Address: 84 Wakefield Road Huddersfield HD8 0BL

Application number: 2024/92112	
What is the application for?:	Demolition of existing dwelling and erection of replacement dwelling
Address of the site or building:	74, Wakefield Road, Lepton, Huddersfield, HD8 0BL
Postcode:	HD8 0BL

Proposed Site Roof Plan 1:200

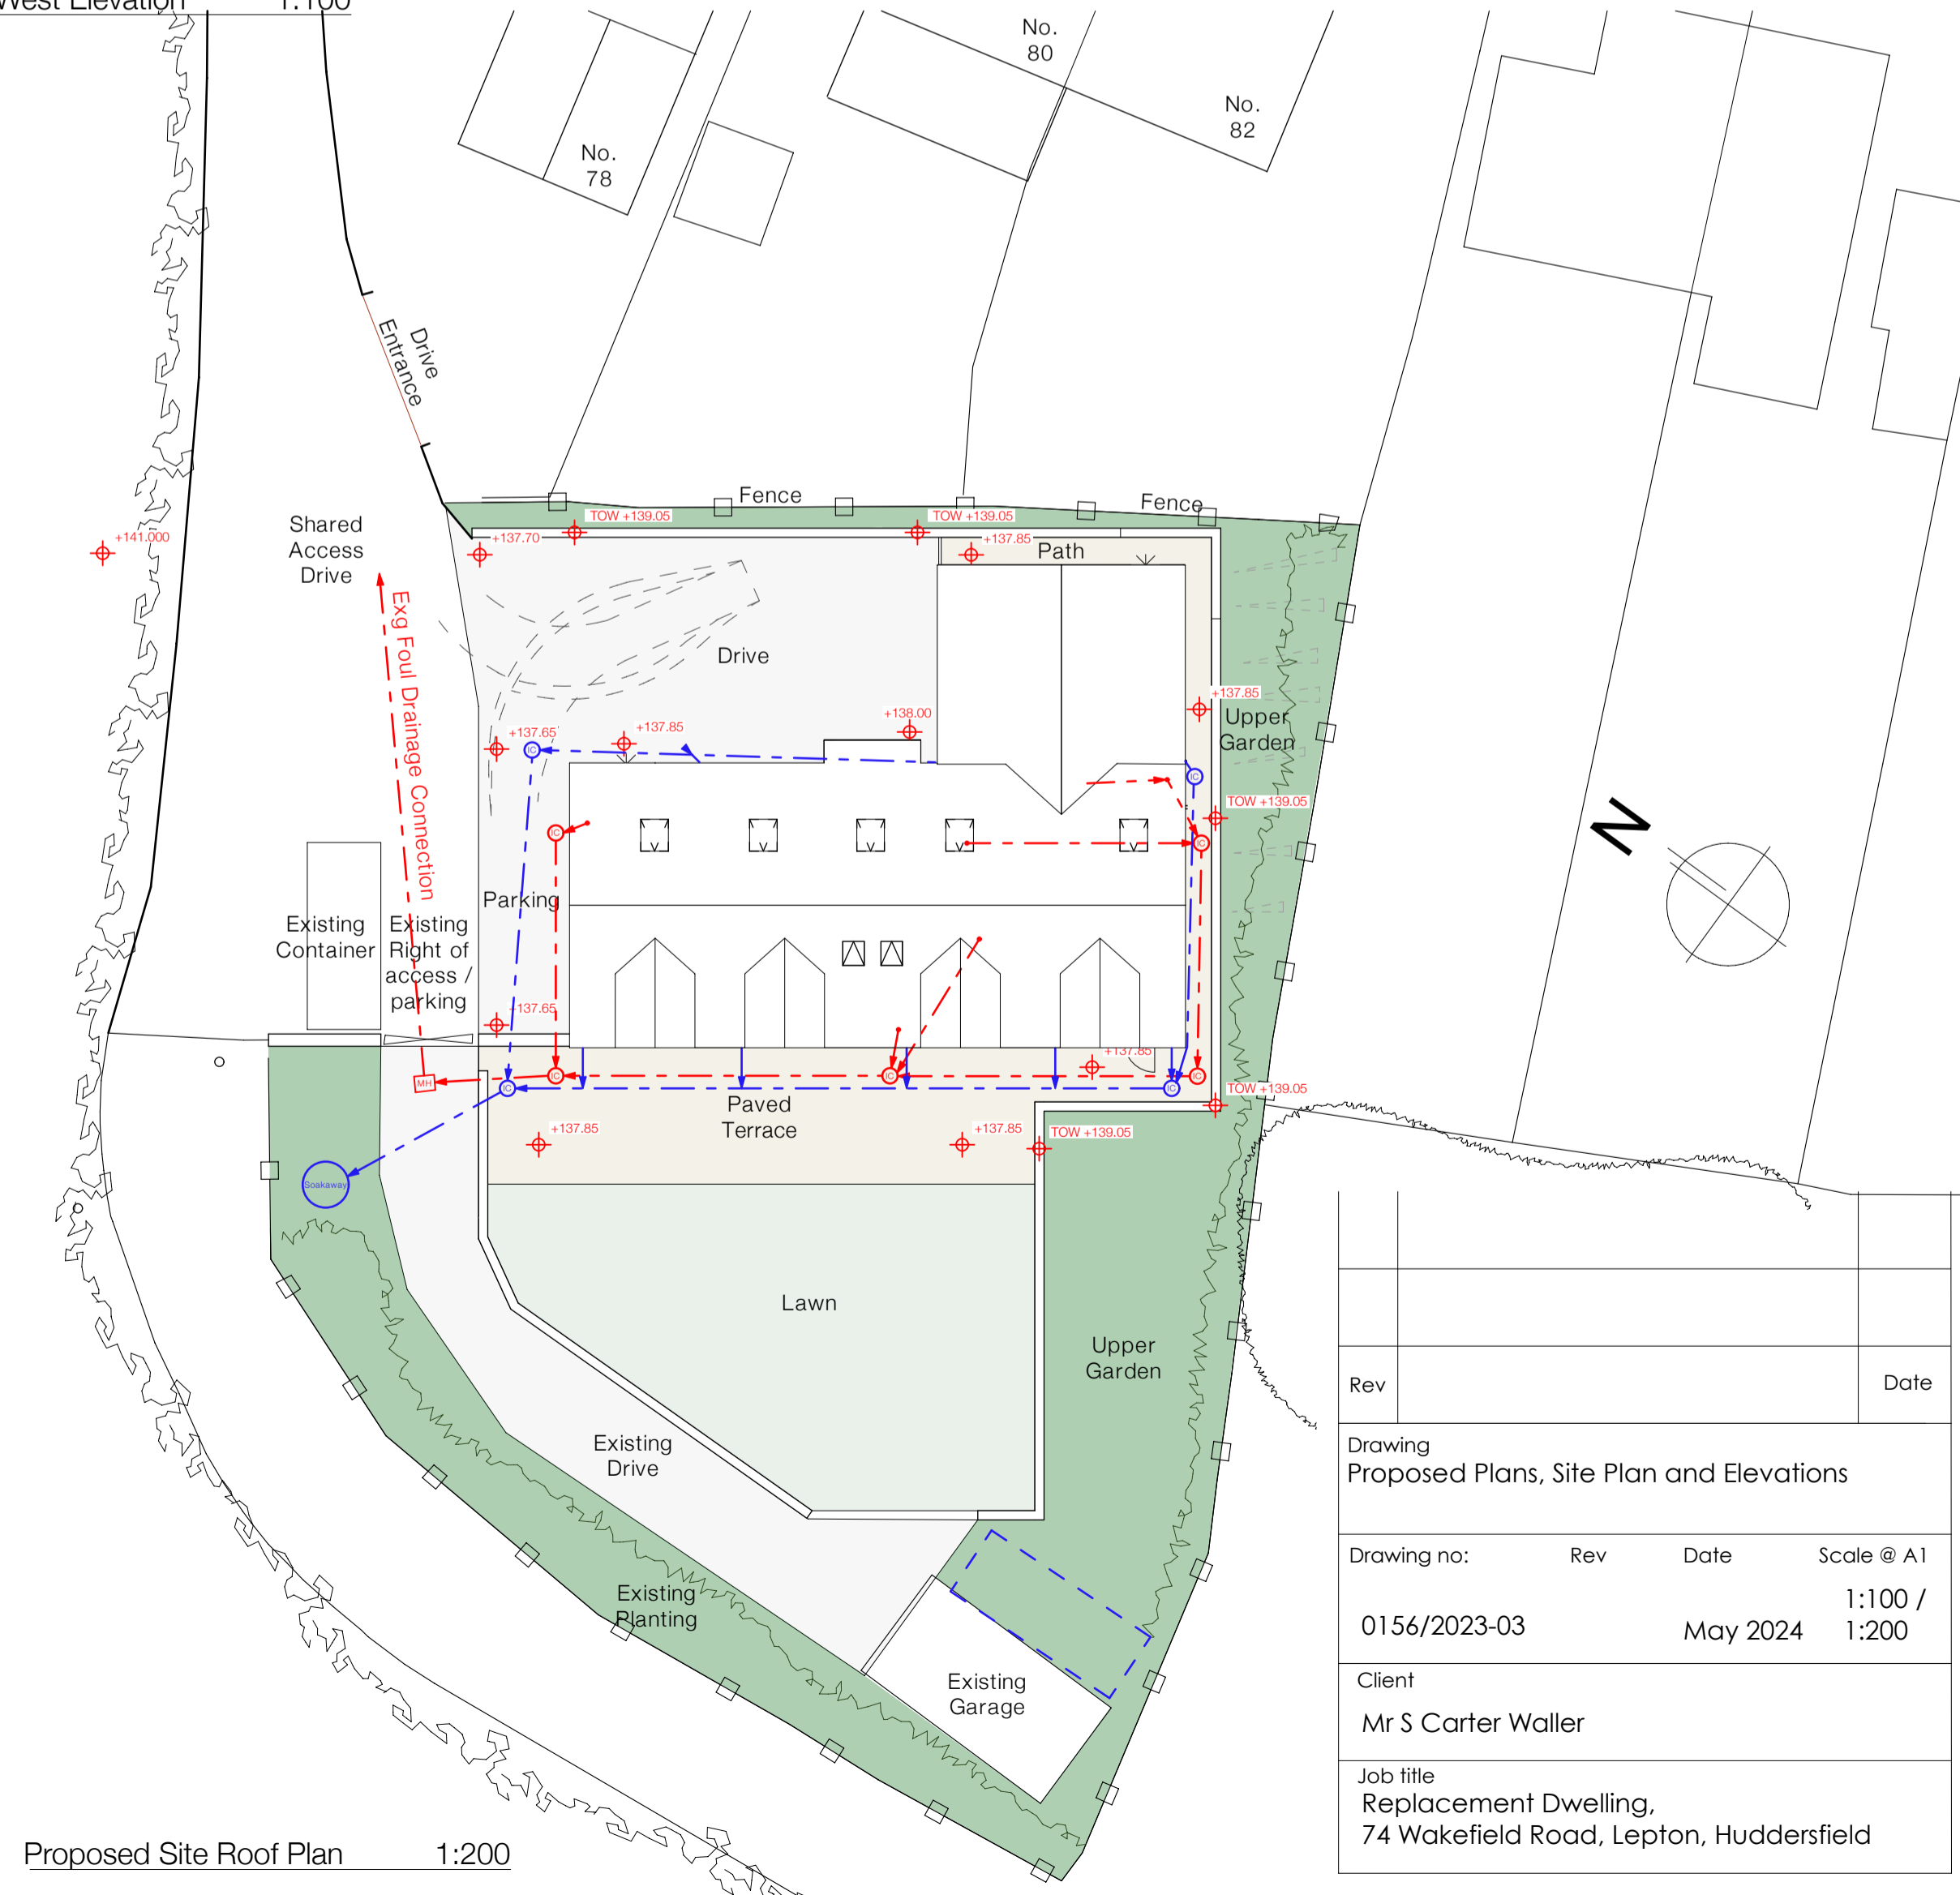
Type of comment: An objection	
Do you wish your comments to be published on the website anonymously?	No
<p>Having reviewed the existing & proposed plans for the dwelling, I have identified several risks that it poses on the neighbouring properties & wildlife.</p> <p>The report from the Coal Authority and Enviro both indicate "substantive" concerns of subsidence at "moderate to high risk". Due to the proposed proximity to my property, this poses a high risk of subsidence on my property also.</p> <p>The proposed plans show a two storey property with bedrooms overlooking my property, imposing on my privacy. Due to the close proximity to the current boundary hedge, there is a risk of reduced light to the boundary hedge, lawn, trees & shrubbery. This will likely have an adverse effect on the wildlife.</p> <p>I am concerned regarding the proper disposal of waste from the development due to experience of disposal/burning of trade and/or domestic waste on neighbouring properties resulting in pollution onto my property.</p> <p style="text-align: center;">I am concerned about noise levels from the development. I note the condition (CSC1) from the Environmental Health response stipulating suitable working times.</p>
